Date: 19th November 2020

Our Ref: Y/101/20/DOC

Town & Country Planning Act 1990 (as amended)
Town and Country Planning (Development Management Procedure) (England) Order 2015
Approval of details reserved by condition imposed under ref Y/61/19/PL relating to Condition Nos 3 -
surface water drainage, 4 - maintenance & management of SuDs system and 6 - hard & soft
landscaping.
Yapton Metal Company Burndell Road Yapton BN18 0HP

DESIGN D3 (UNDER VERGES - <900 COVER)
DESIGN D4 (UNDER CARRIAGEWAYS - <1200 COVER)
BEDDING DETAIL - CLASS 'Z'

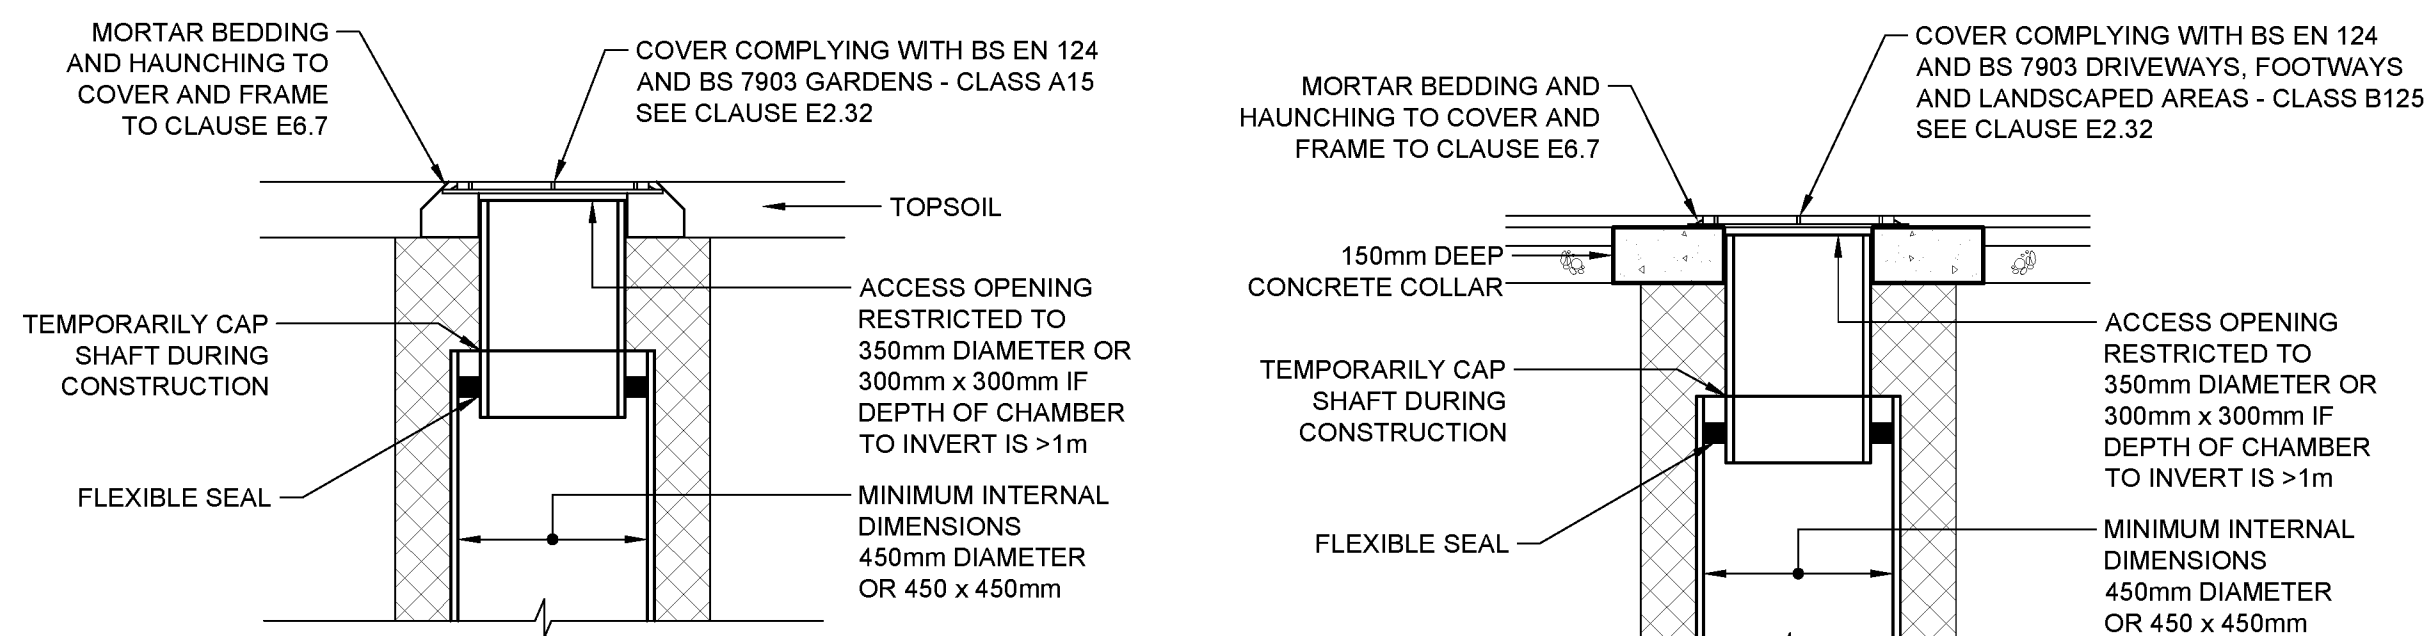
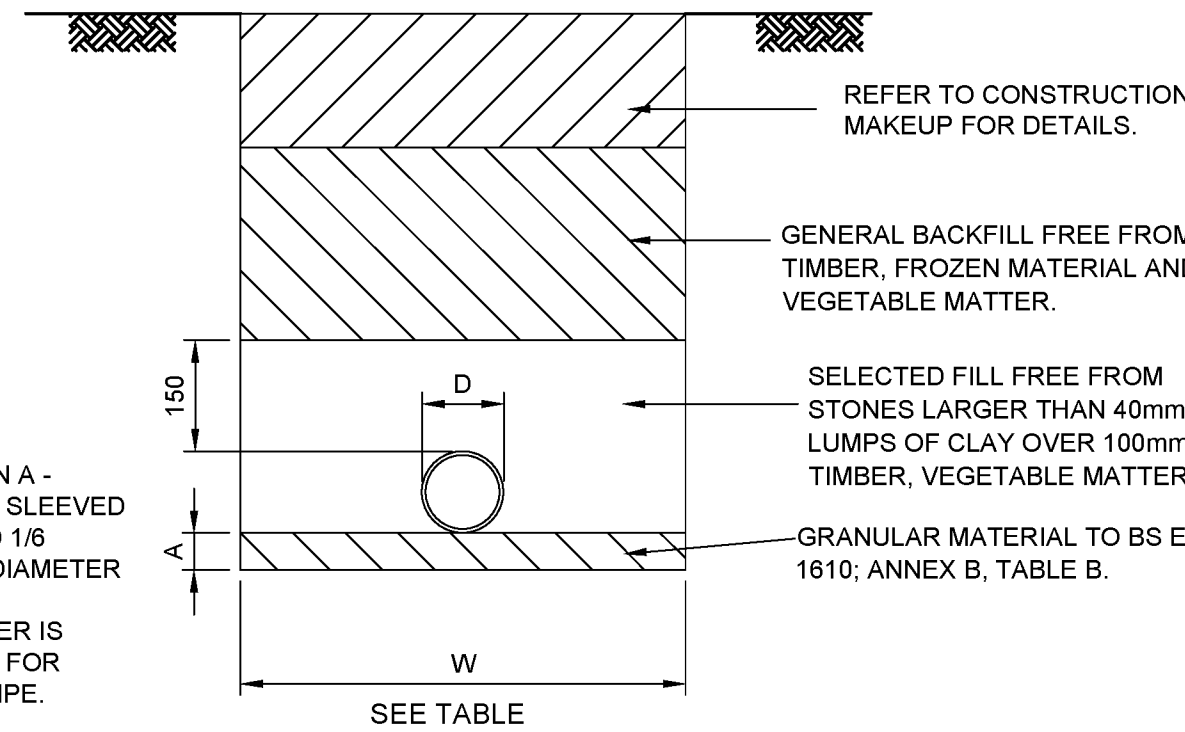
Note, for future applications we would expect to see a Class Z pipe bed and surround (full concrete surround) for pipes laid at this depth under vehicular areas. However, given that all other previous points have been met, and given the prolonged consultation stage it will be overlooked in this instance.
